Engineers comments on surface water drainage;

APPLICATION NO: F/5/20/PL

Site Address: Ford Airfield Market West Sussex BN18 0FL

Description of Works: Reconfiguration of Ford Market, including revised market access, hardstanding for replacement vehicular parking and associated infrastructure, landscape, ancillary and site preparation works

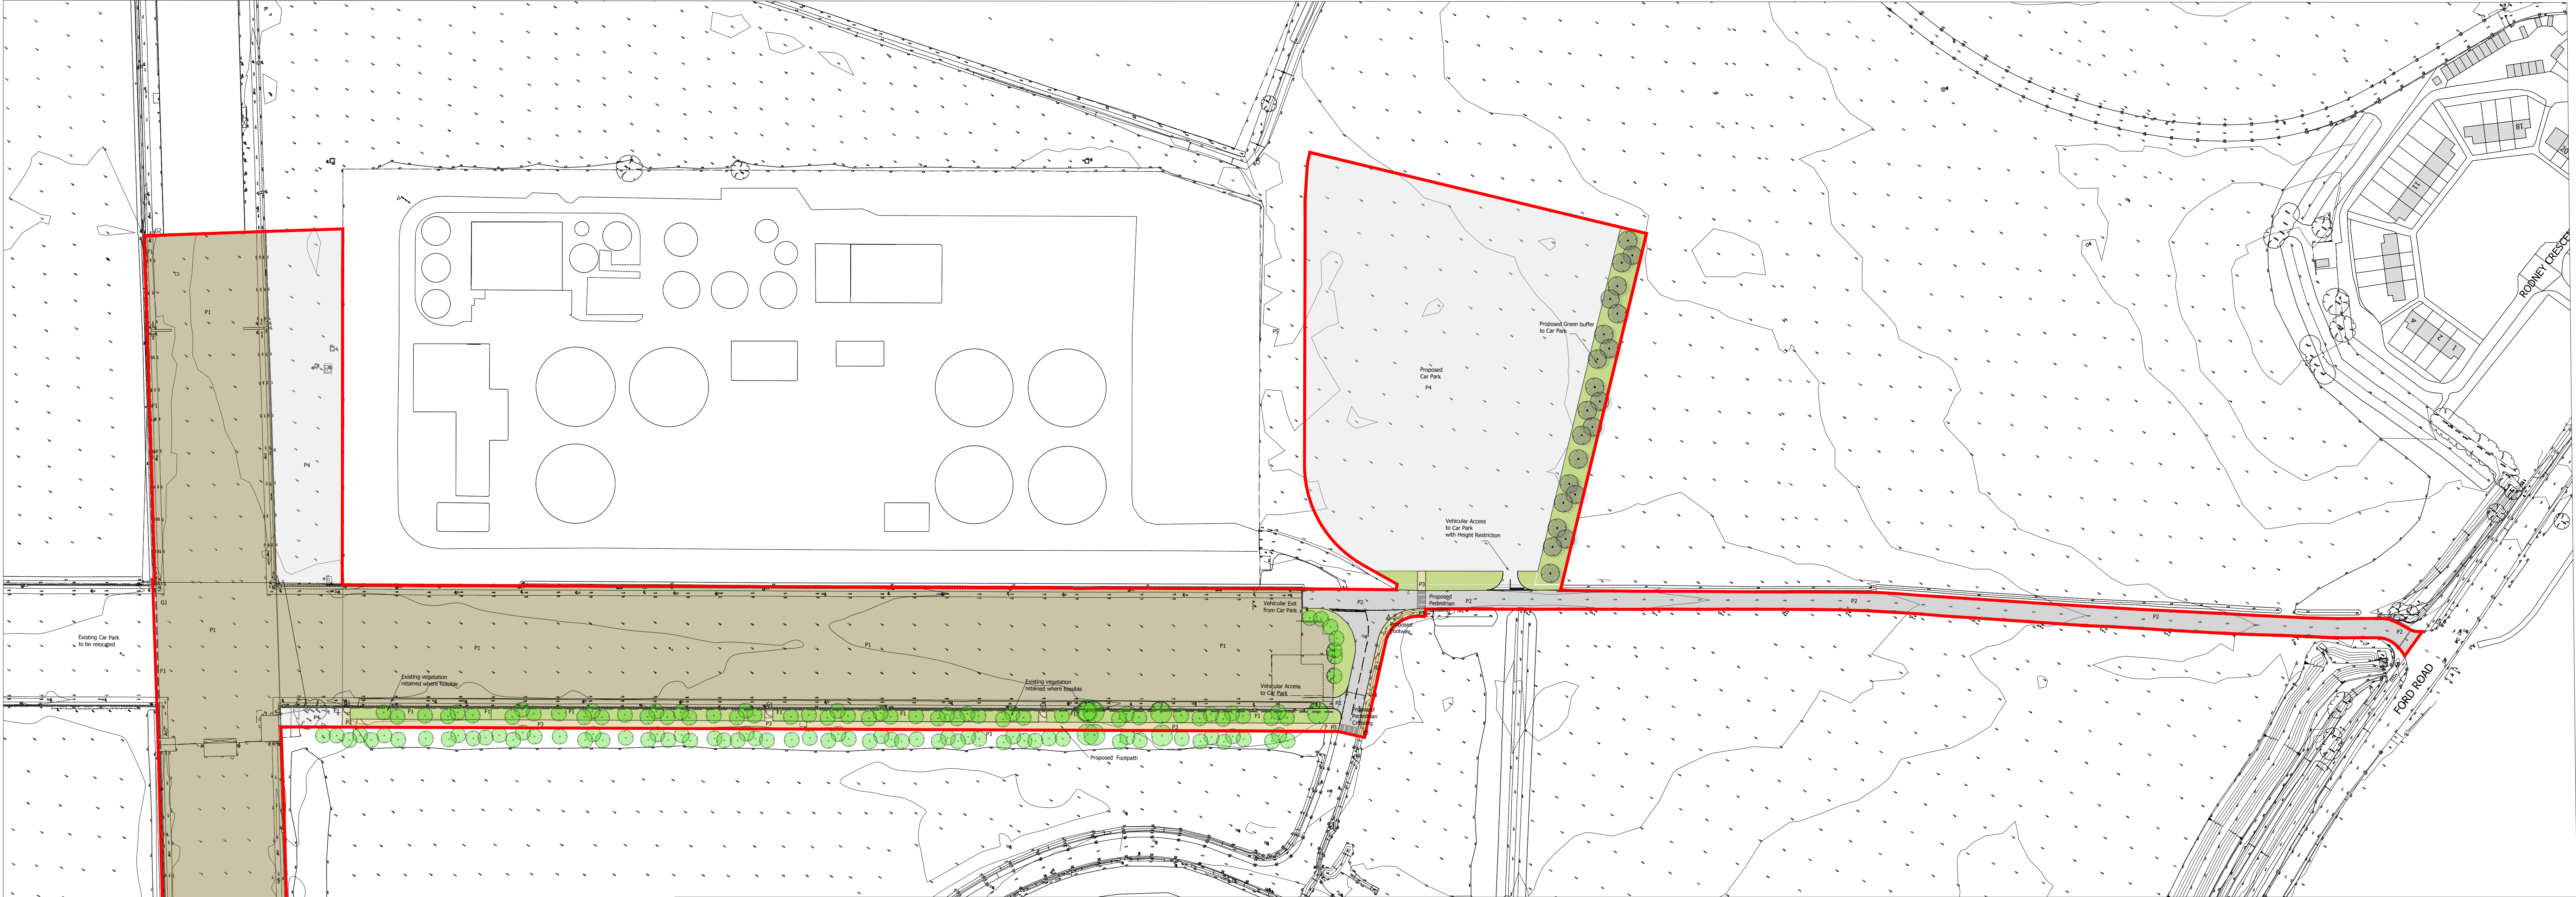
1. It is noted that the existing access road and runways will not be altered and therefore the drainage regime for these will remain unchanged.
2. The intention is for the proposed overflow carpark to have a permeable surface (good for water treatment) and to discharge to ground via infiltration.

3. Peak winter groundwater levels at this location were found to be 3.9m below ground level, however, infiltration testing (to BRE365) was carried out in the summer (Aug 2018), giving an infiltration rate of 4.76×10^{-6} m/s. This rate gives an indication that infiltration could be possible, however, it cannot be used in the design, as winter testing is required. This fact is recognised in the Flood Risk Assessment, with the intention of undertaking further testing to BRE365 in Feb 2020. These results would not yet appear to be available but will be critical to the strategy.

4. The detailed drainage design will be considered further once more information is available. Please could you therefore apply standard condition **PCENG2**;

“Development shall not commence, other than works of site survey and investigation, until full details of the proposed surface water drainage scheme have been submitted to and approved in writing by the Local Planning Authority. The design should follow the hierarchy of preference for different types of surface water drainage disposal systems as set out in Approved Document H of the Building Regulations, and the recommendations of the SuDS Manual produced by CIRIA. Winter groundwater monitoring to establish highest annual ground water levels and winter Percolation testing to BRE 365, or similar approved, will be required to support the design of any Infiltration drainage. No building / No part of the extended building shall be occupied until the complete surface water drainage system serving the property has been implemented in accordance with the agreed details and the details so agreed shall be maintained in good working order in perpetuity.”
